From: Simon Davis
Sent: 11 January 2022 10:41
To: Planning Scanning
Subject: FW: *EXTERNAL: RE: Drove Lane, Yapton - Conditions Y/156/21/DOC & Y/167/21/DOC

From: Simon Davis
Sent: 11 January 2022 10:37
To: 'Havis, Sean' [REDACTED]
Cc: Sparkes, Jessica [REDACTED]
Subject: RE: *EXTERNAL: RE: Drove Lane, Yapton - Conditions

I have had a response from WSCC PRow re Y/167/21/DOC (cond 5):

LEVELS AND DRAINAGE PLAN

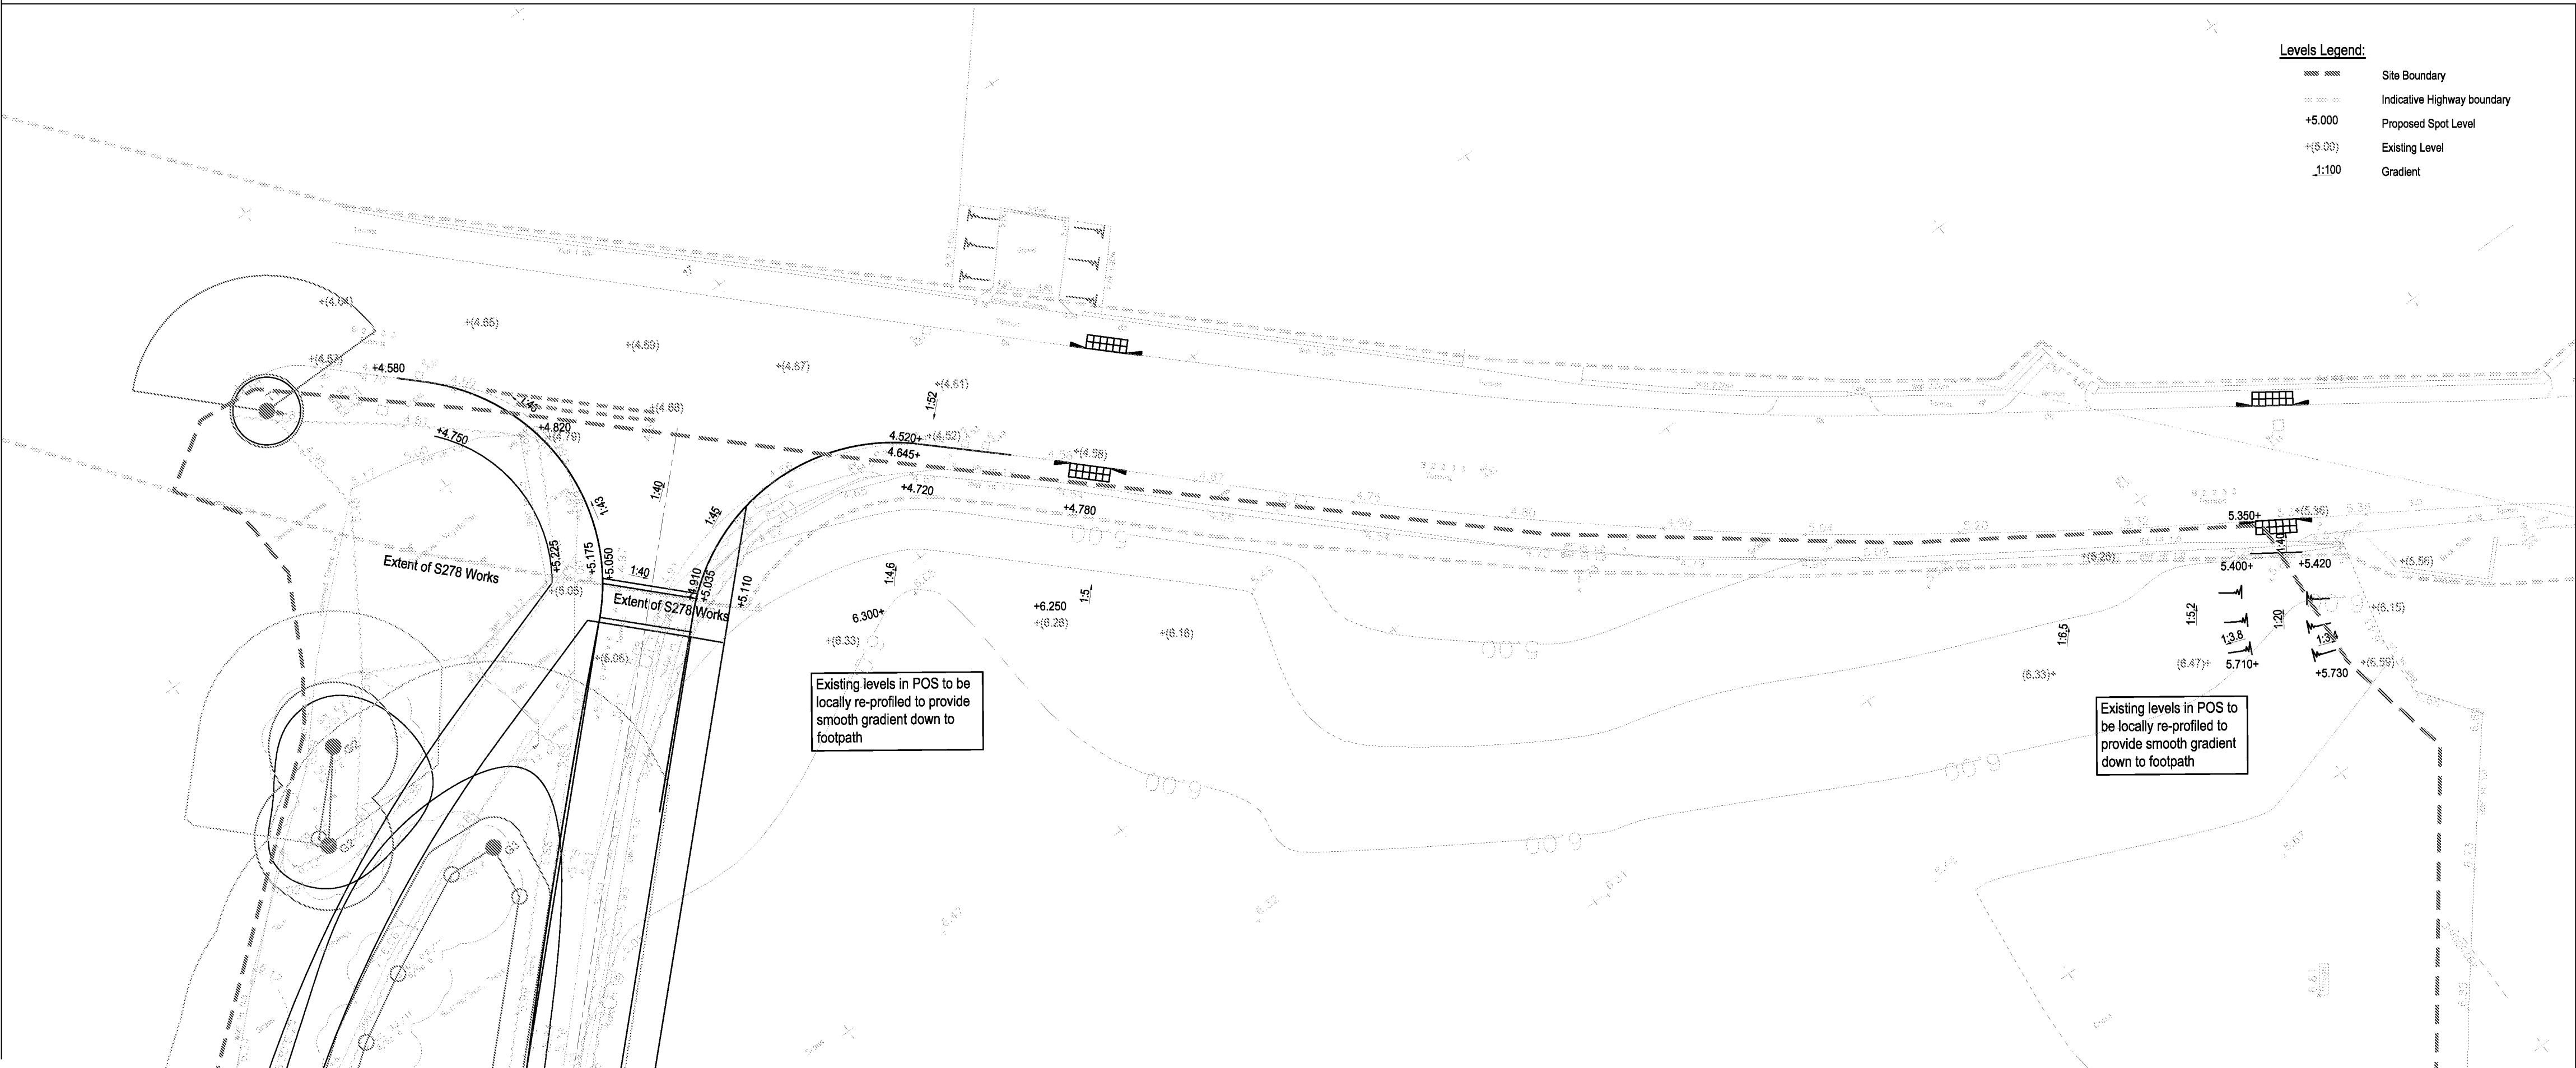
I note that the developer plans to surface FP 157 and FP200_1 with Flexipave surfacing with timber edging or similar and approved. As the Highways Authority responsible for ongoing maintenance of these footpaths please advise regarding the durability and ongoing maintenance required for such a surface, particularly in comparison to a rolled stone surface or tarmac, our preference for footpaths in urban areas as this will become. If not using Flexipave surfacing but something 'similar and approved', please advise what this might be. Please do not commence any footpath works without West Sussex County Council's approval.
